I am objecting to this application (ref **OWPC15638**) on the grounds that it does not protect neighbours privacy from overlooking and I am attaching some photos to support my objection.

WA/57/17/PL

PROPOSED ELEVATIONS 1:100

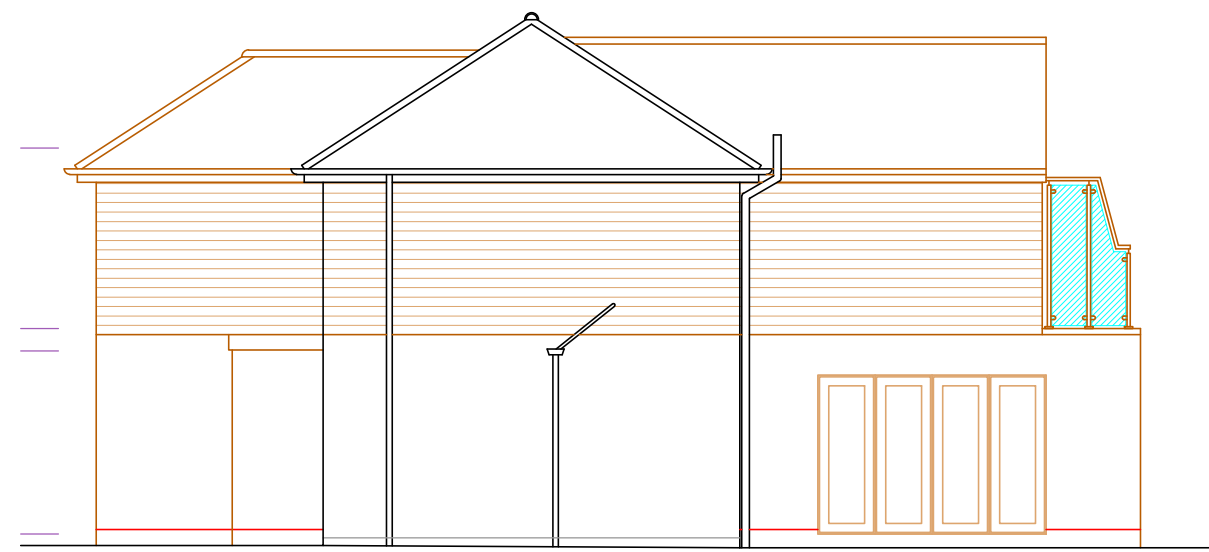
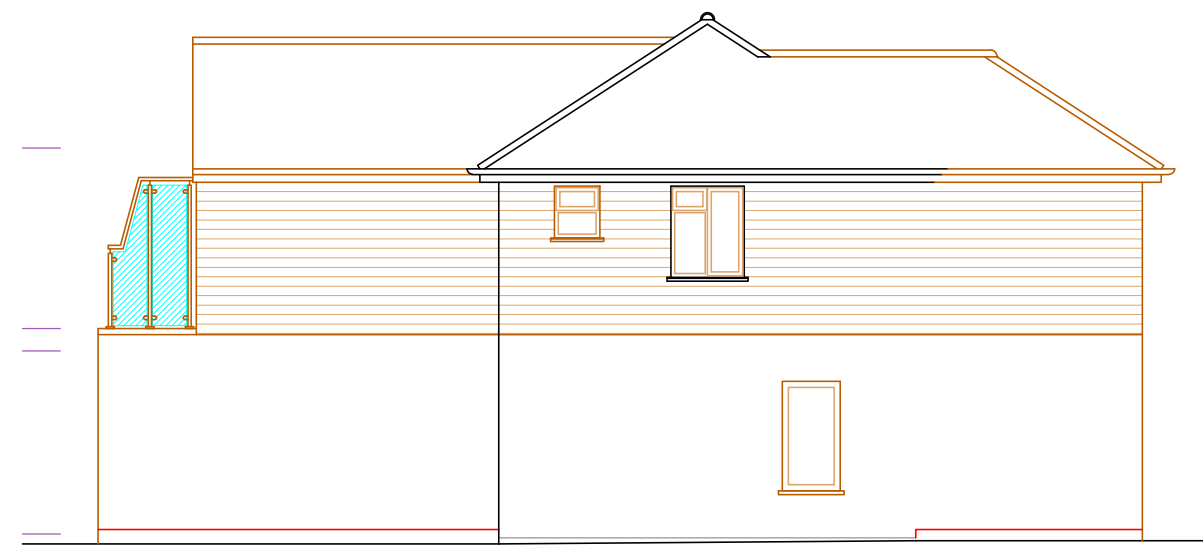
Two views from northern neighbour's patio showing that the screening for which permission is sought can easily be looked over or through and offers no protection for neighbours' privacy

Two views showing clearly the gaps around the balustrade and panels, meaning that they do not form a meaningful barrier to overlooking.
